**From:** Silvie Steiningerova  
**Sent:** 18 August 2026 11:31  
**To:** Planning.Responses  
**Subject:** FW: Y/47/26/HH- Flints, Hoe Lane  
**Attachments:** Heritage Statement.pdf

**From:** Jack Dowling [REDACTED]  
**Sent:** 12 August 2026 13:41  
**To:** Silvie Steiningerova <[Silvie.Steiningerova@arun.gov.uk](mailto:Silvie.Steiningerova@arun.gov.uk)>  
**Subject:** RE: Y/47/26/HH- Flints, Hoe Lane

**Subject:** Y/47/26/HH- Flints, Hoe Lane

Existing East Elevation

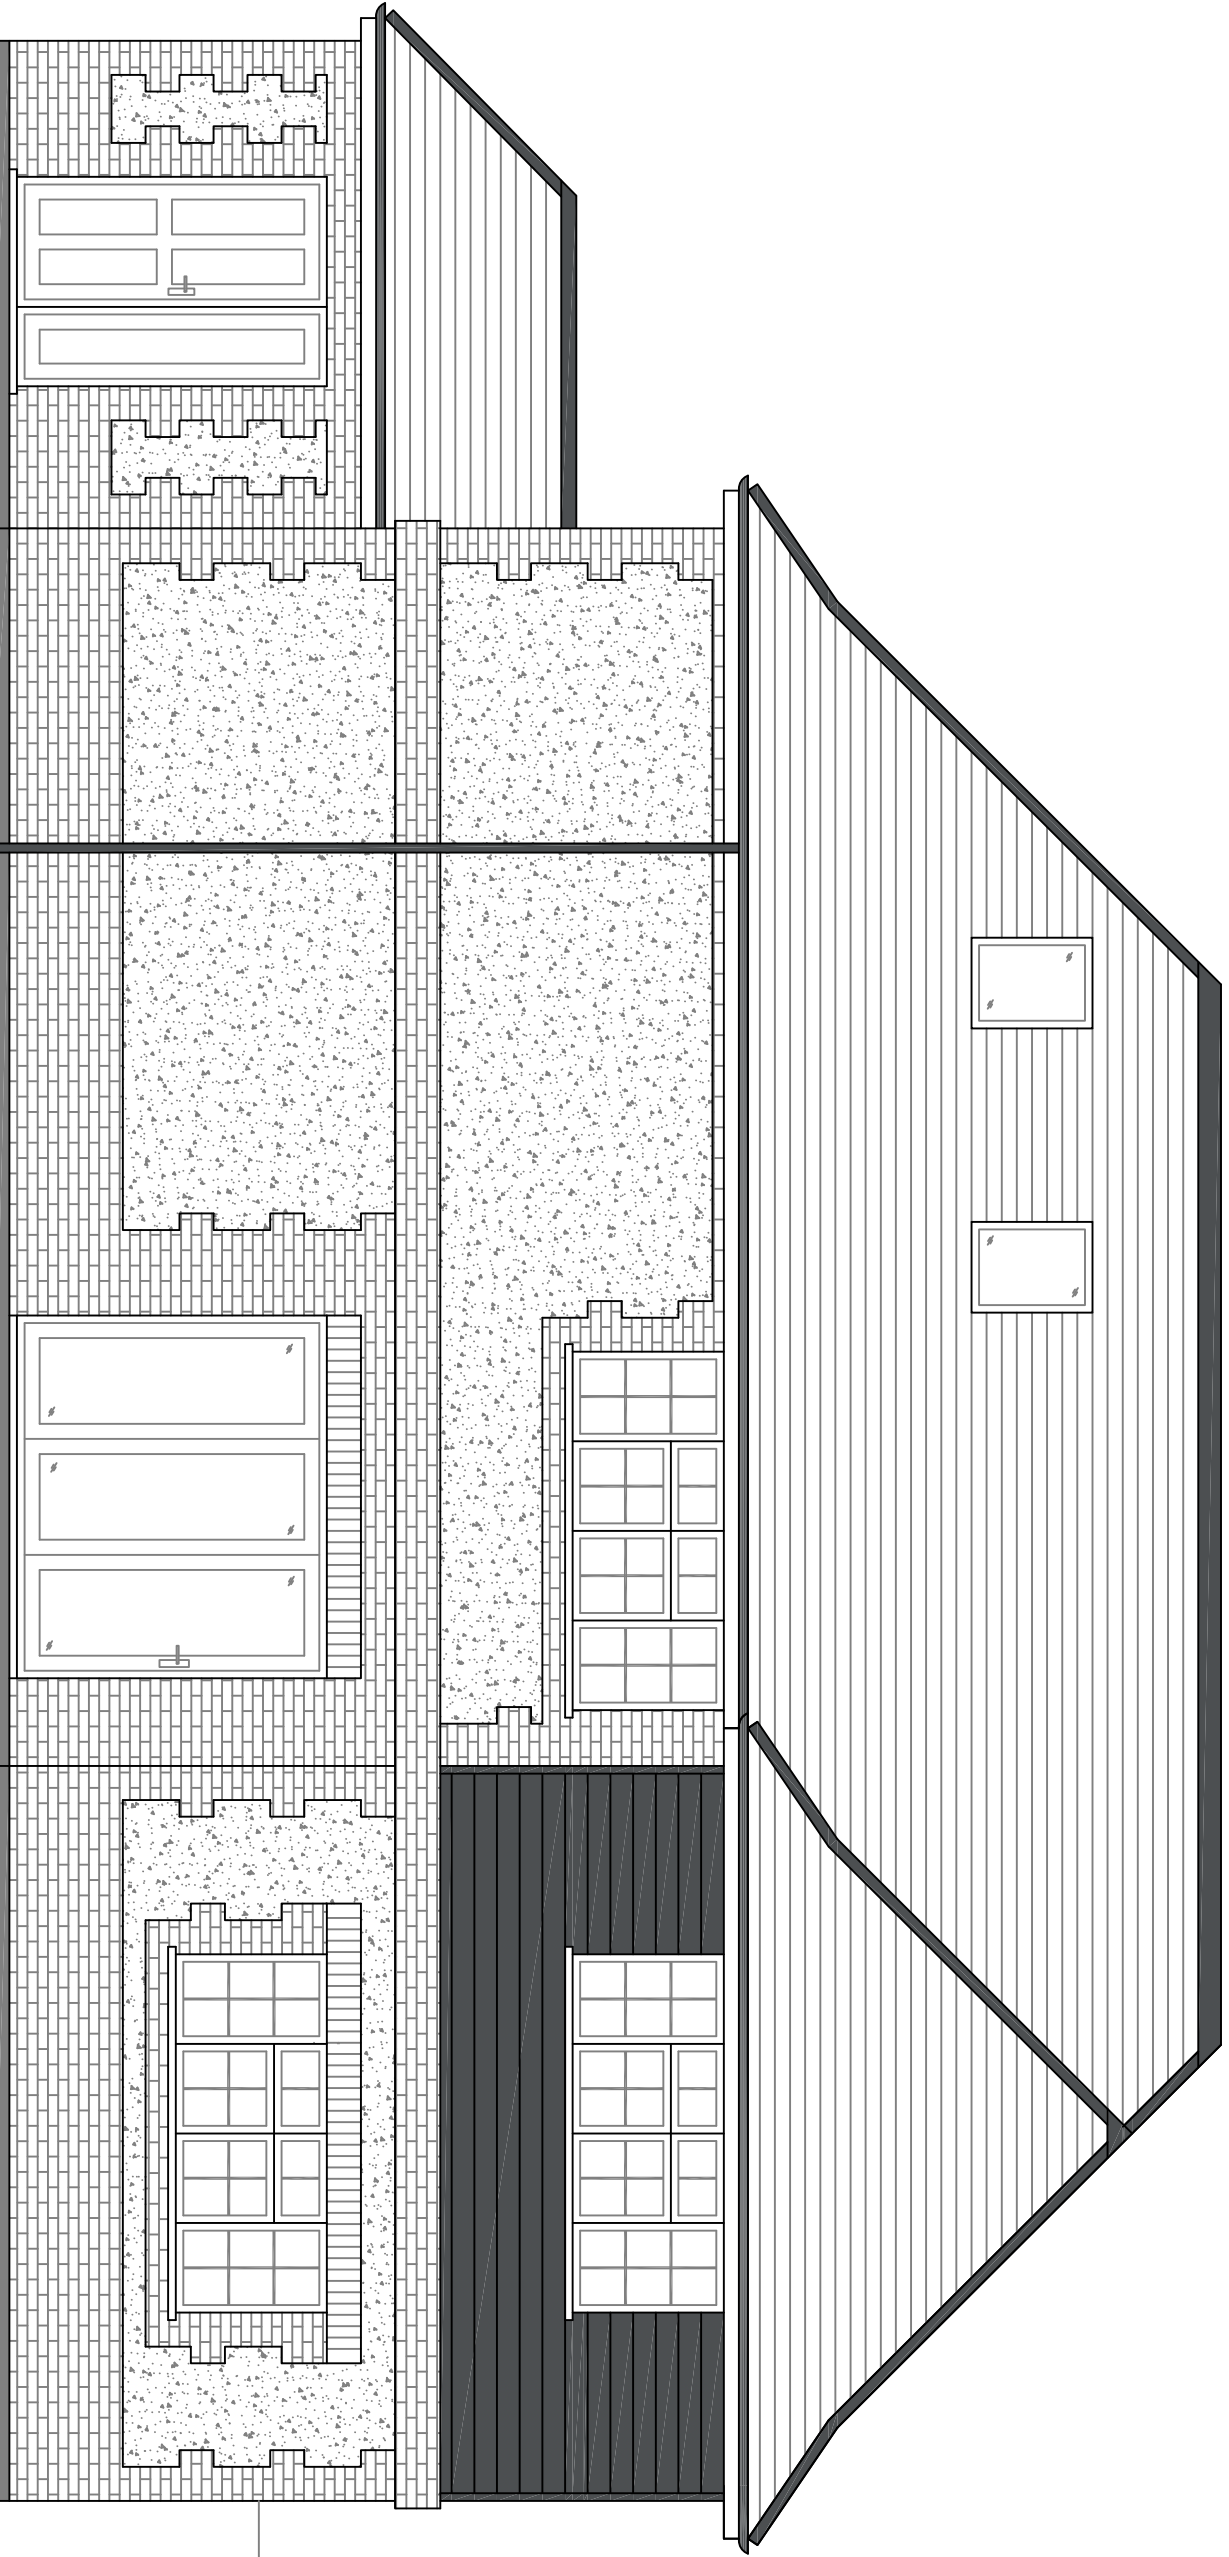
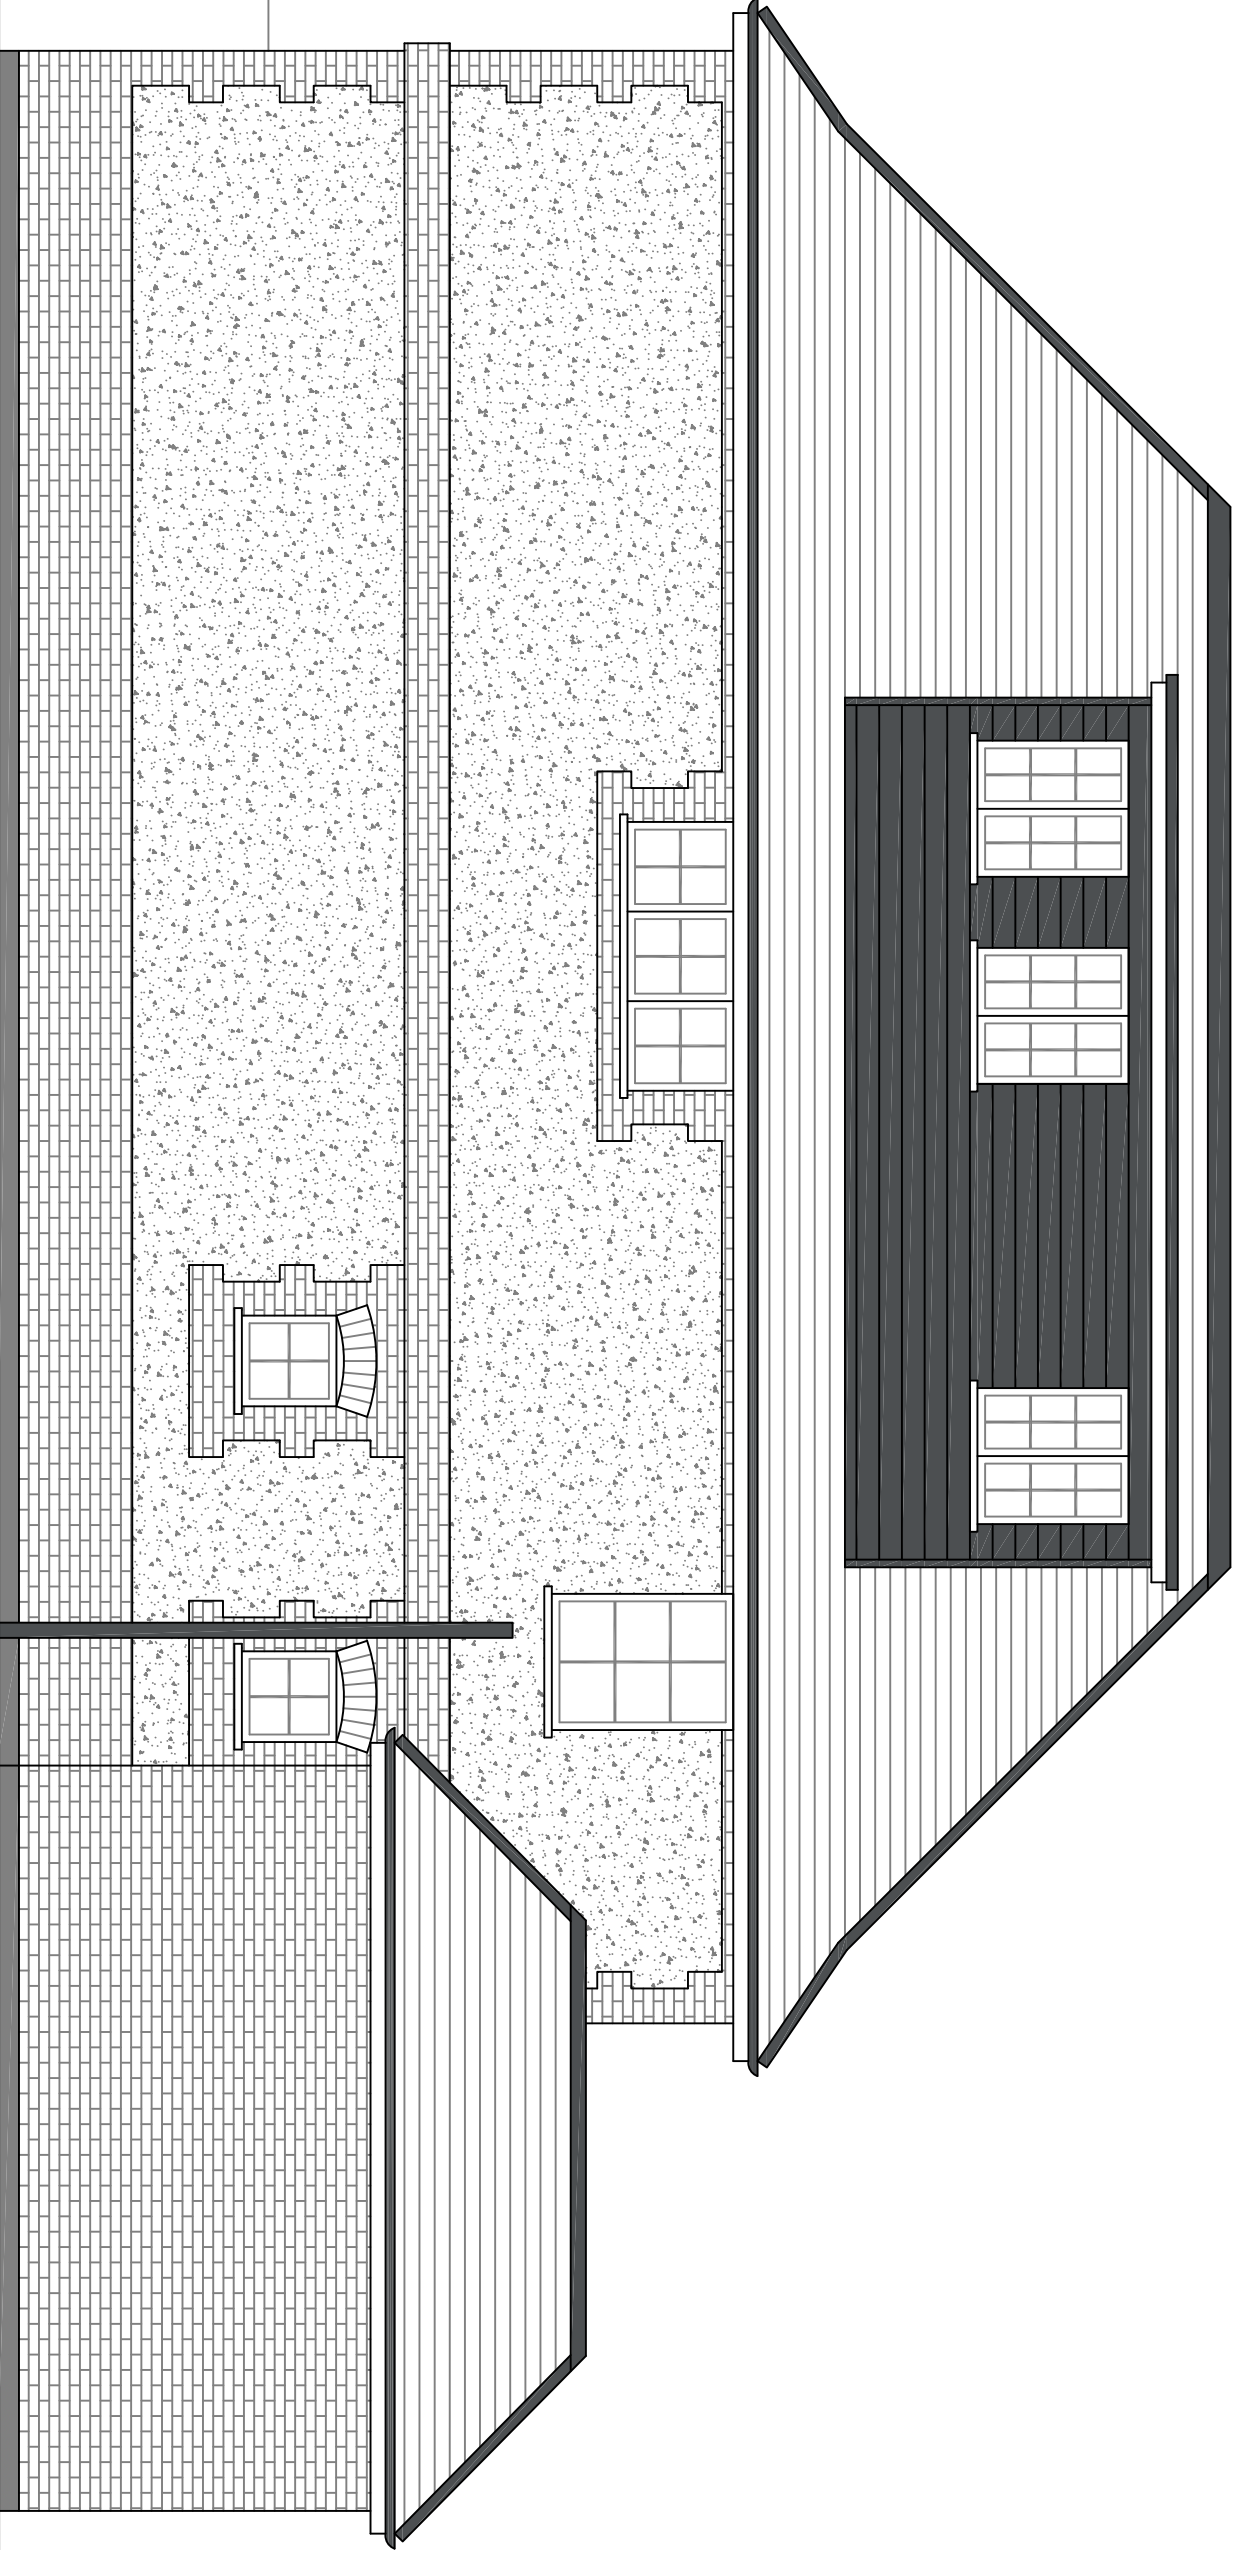
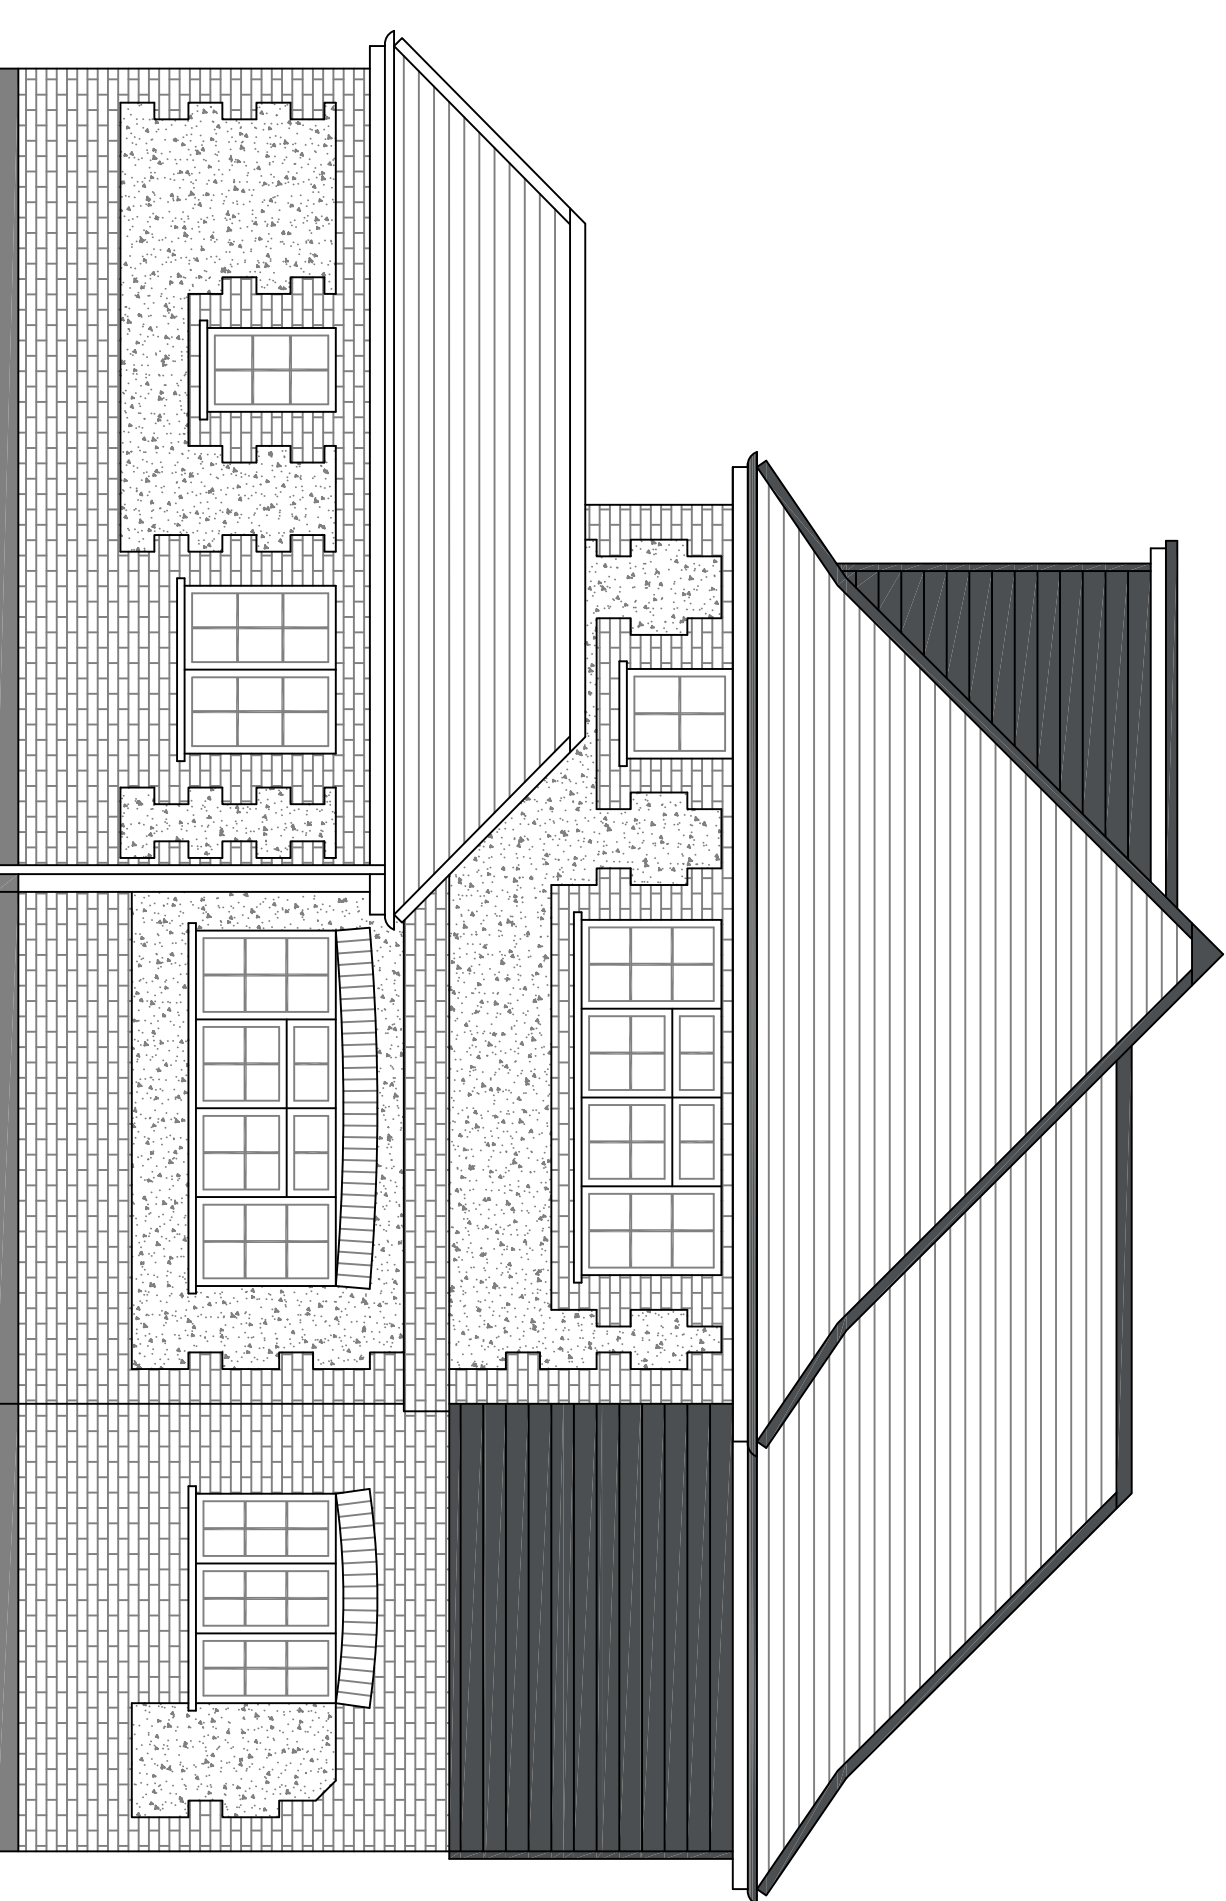
I visited the site today and noted that the dormers are currently under construction and have not yet been completed. As such, the submitted drawings and application description do not accurately reflect the existing dwelling.

The submitted existing drawings appear to show alterations that were submitted under the previous permission and I want to ensure that the existing drawings accurately reflect the dwelling as it currently exists on site.

The dormer and first floor extension have been implemented, just the ground floor was smaller than they wanted so that's been resubmitted. Thanks
